DFT PR-2024-010446

SI-2024-00774

RESPONSE TO: Code Enforcement Comments

1 ELECTRICAL SITE PLAN

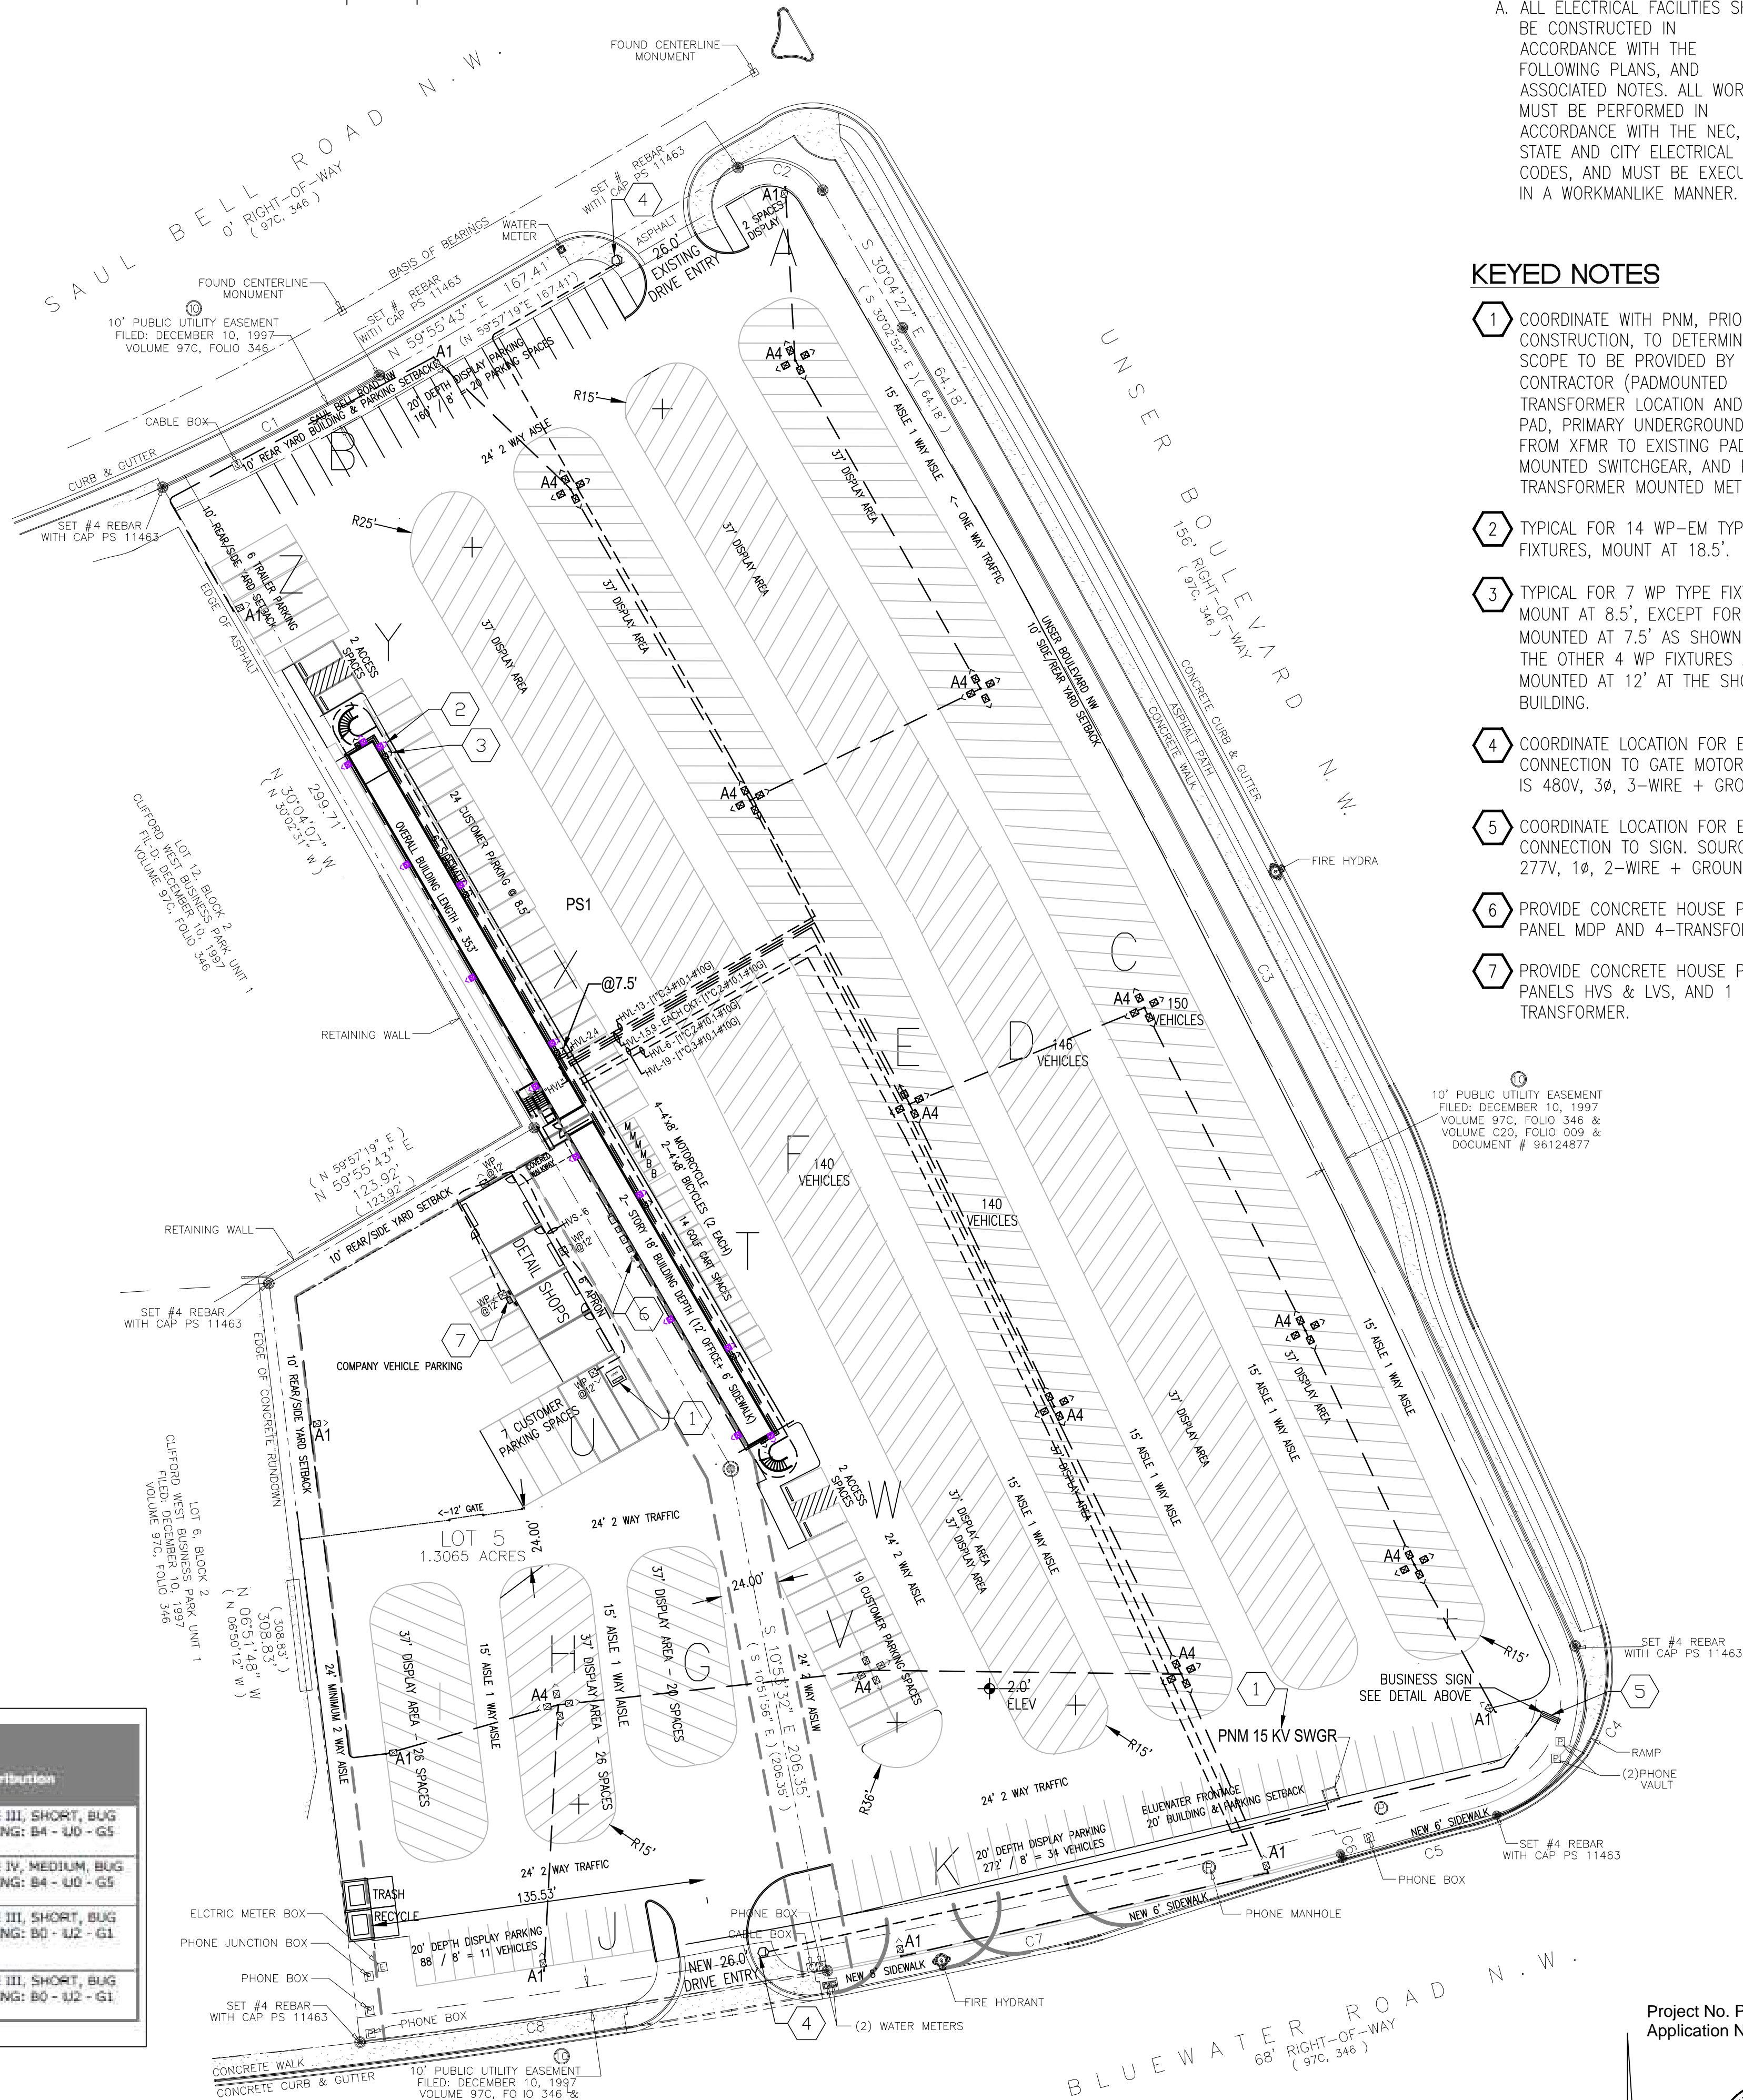
▪ **Provide a lighting plan with dimensions that meet the Clifford plan requirements.**

The exterior area lighting plan Sheets E1 and E1 Supplement have been clarified to improve the readability of illumination levels and dispersion patterns. (Enclosed)
The light trespass limits surrounding the fence line are within 0.8 fc. The main site lighting is bordered by three streets: Saul bell Road NW, Unser Boulevard NW and Bluewater Road NW. The foot candle level on the fence line is the minimum for video surveillance to pick up activity to dispatch a quick response team with adequate information. **Exterior Lighting Compliance Certificate is also enclosed.**

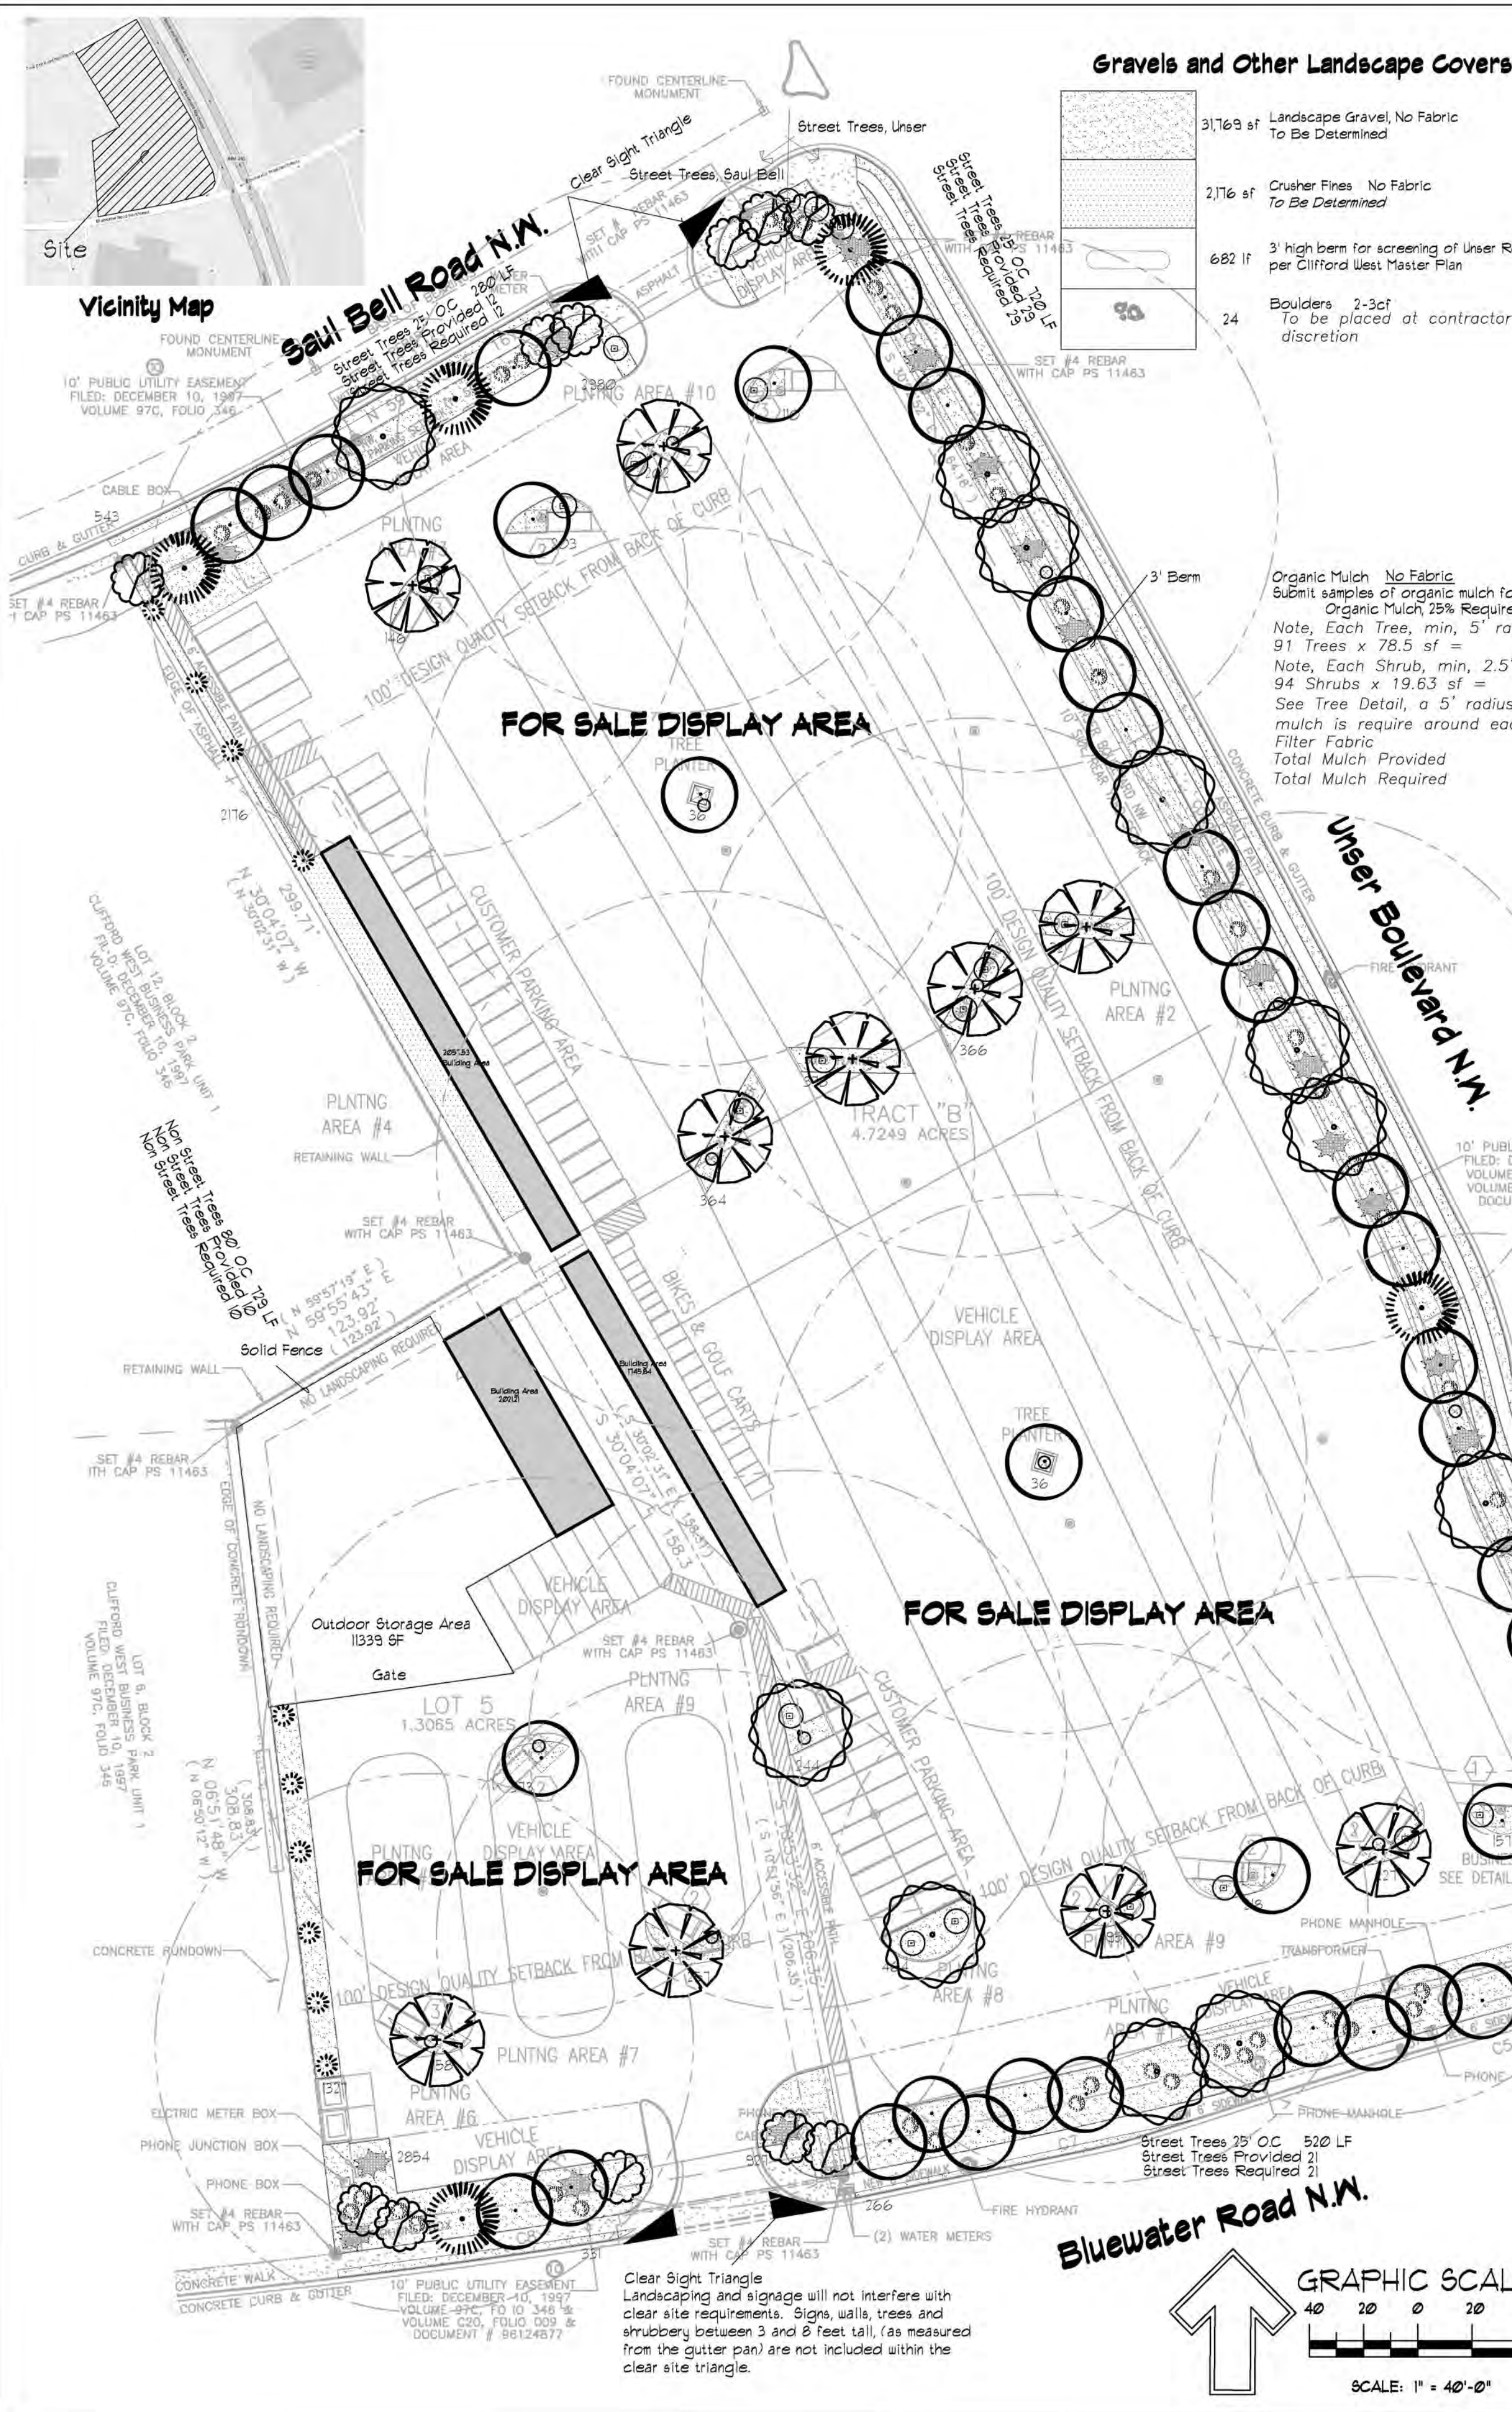
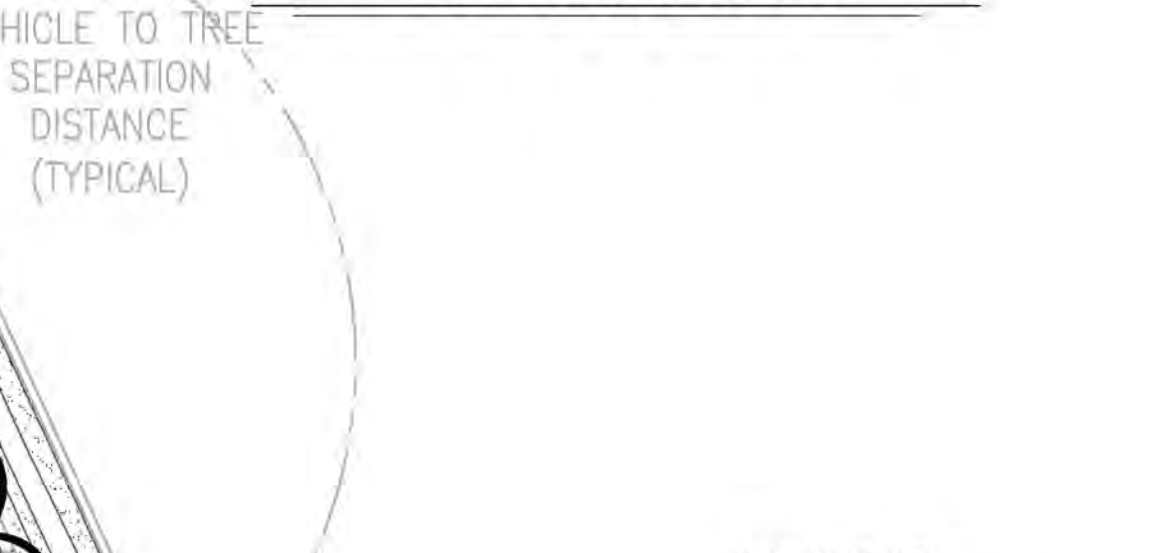
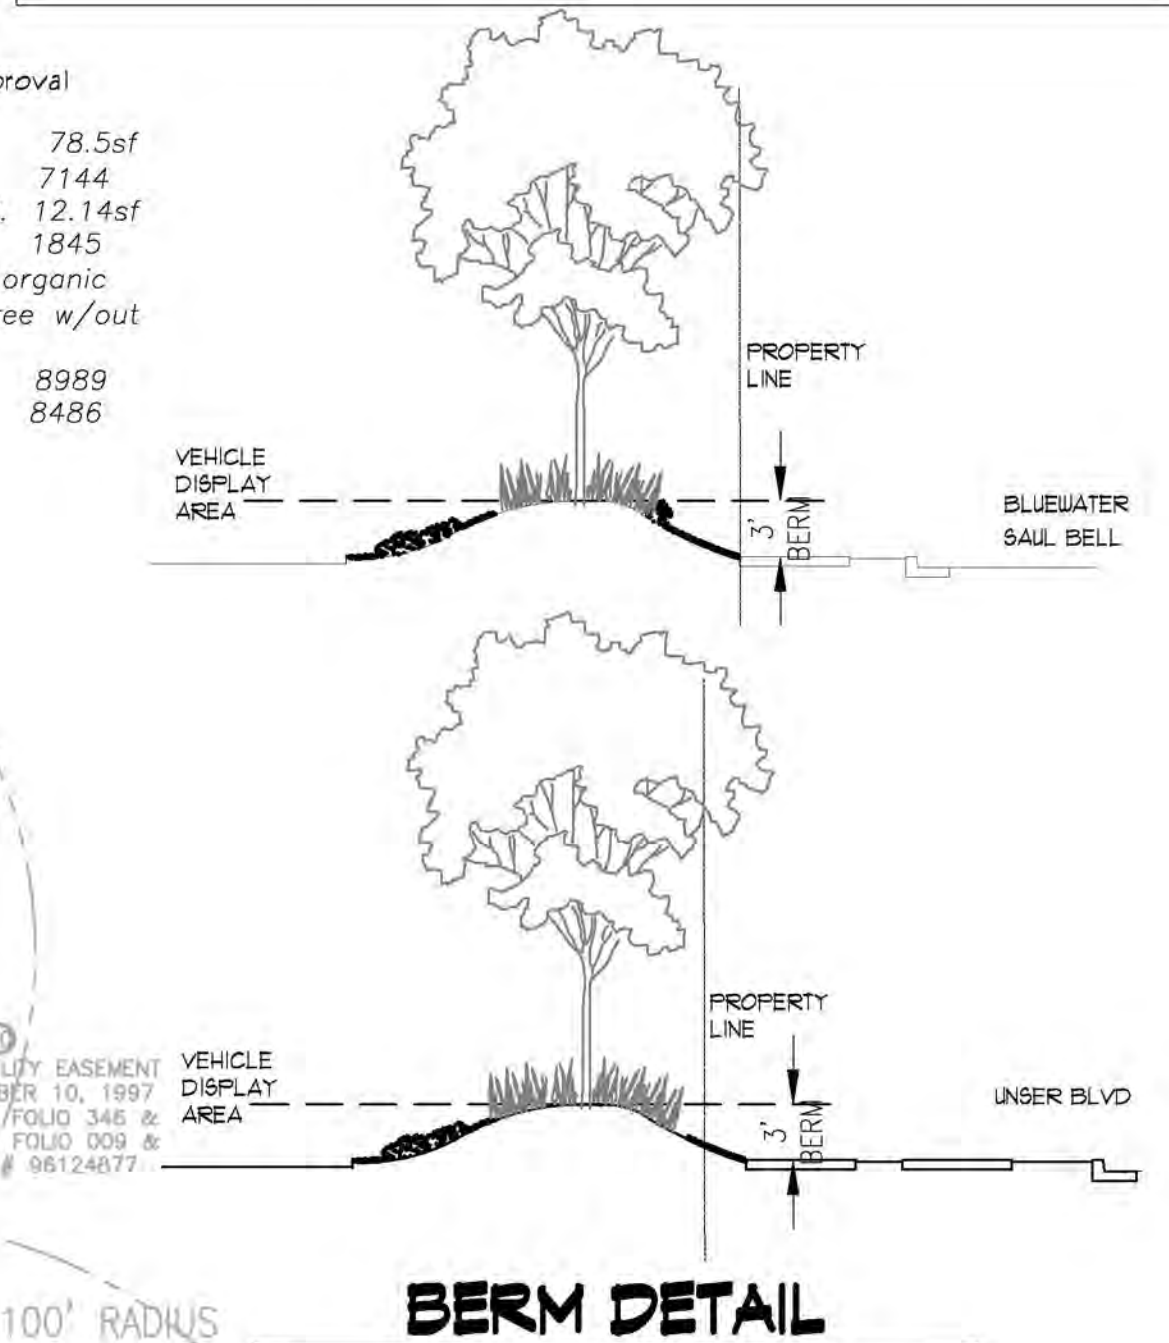
▪ **Clarify the landscape calculation of the net lot area. Calculations must show how the Entire development meets the minimum requirement(s). *Plan should note/demonstrate how all relevant sections within both the Clifford Park plan and IDO section 5-6 are being met. “;**

(Include and describe how these citations are being met: CWBP MP and IDO: 5-6-C; 5-6-C-2; 5-6-D; 5-6-E-2; 5-6-F; 5-6-G)

ARCHITECTURAL SITE PLAN CALCULATIONS:											
REQUIRED LANDSCAPE AREA GROSS DEVELOPED AREA: 262,667 GSF BUILDINGS TOTAL FOOTPRINT: 5,925 GSF VEHICLE STORAGE AREA: 11,339 GSF <hr/> NET LOT AREA: 245,403 GSF REQUIRED LANDSCAPE AREA @ 18% 44,172 GSF VEHICLE DISPLAY AREAS PERVIOUS PAVING DISCOUNT @ 25% 11,043 GSF <hr/> REQUIRED AREA: 33,129 GSF					DECIDUOUS AND EVERGREEN TREES STREET TREES: REQUIRED UNSER BOULEVARD: 720 LF @ 1/25 LF = 29 SAUL BELL ROAD: 280 LF @ 1/25 LF = 12 BLUEWATER ROAD: 520 LF @ 1/25 LF = 21 <hr/> TOTAL TREES THIS AREA TYPE: 62 PROPERTY LINE TREES: REQUIRED LOT 5: 429 LF @ 1/80 LF = 6 TRACT B: 300 LF @ 1/80 LF = 4 <hr/> TOTAL TREES THIS AREA TYPE: 10 PARKING AREAS: REQUIRED LOT 5: 87 SPACES @ 1/10 STALLS = 9 TRACT B: 659 SPACES @ 1/10 STALLS = 66 <hr/> TOTAL TREES THIS AREA TYPE: 75 TOTAL TREES THIS PROJECT: 91						
LANDSCAPE PROVIDED											
AREA 1:	7,602 SF	AREA 7:	797 SF

AREA 2:	13,058 SF	AREA 8:	287 SF								
AREA 3:	2,938 SF	AREA 9:	241 SF								
AREA 4:	2,295 SF	AREA 10:	661 SF								
AREA 5:	1,254 SF	AREA 11:	730 SF								
AREA 6:	2,554 SF	AREA 12:	1,528 SF								
TOTAL PROVIDED: 33,945 SF											
TREE LOCATIONS AND QUANTITIES FOR 75% PLANT COVERAGE											
TREE QUANTITIES BY LOCATIONS						PROVIDED				CANOPY COVERAGE	
	NORTH	SOUTH	EAST	WEST	INTERIOR	TOTALS	AREA	QUANTITY	TOTAL		
REDBUD	5	7	7	-	-	19	177 SF x	19	3,363 SF		
OAK	1	1	4	-	2	8	2826 SF x	8	22,608 SF		
PINE	2	4	3	-	-	9	490 SF x	9	4,410 SF		
F-ELM	2	5	10	-	7	24	707 SF x	24	16,968 SF		
A-ELM	-	-	-	-	10	10	1256 SF x	10	12,560 SF		
JUNIPER	2	4	5	-	-	21	28 SF x	21	588 SF		
SUBTOTALS	12	21	29	-	19	91	AREA PROVIDED		64,519 SF		
REQUIRED	12	21	29	-	19	91					
REQUIRED LANDSCAPE AREA 33,129 SF REQUIRED COVERAGE AREA @ 75% OF THE REQUIRED LANDSCAPE AREA 24,847 SF PROVIDED TOTAL CANOPY COVERAGE AREA 60,497 SF

The CWMP Section **LANDSCAPE AREA** details various means of and measures to be employed in the design and implementation of landscaping on the property. Refer to the earlier narrative describing the landscape design basis and the calculations for the landscaped areas. IMPERVIOUS PAVING CREDIT @ 25% OF TOTAL REQUIREMENT 11,043 SF (IDO 5-6(F)(1)(g) The landscape area may be reduced by up to 25 percent if the surface of the parking or vehicle circulation area is of a permeable material with approval from the Planning Director.)
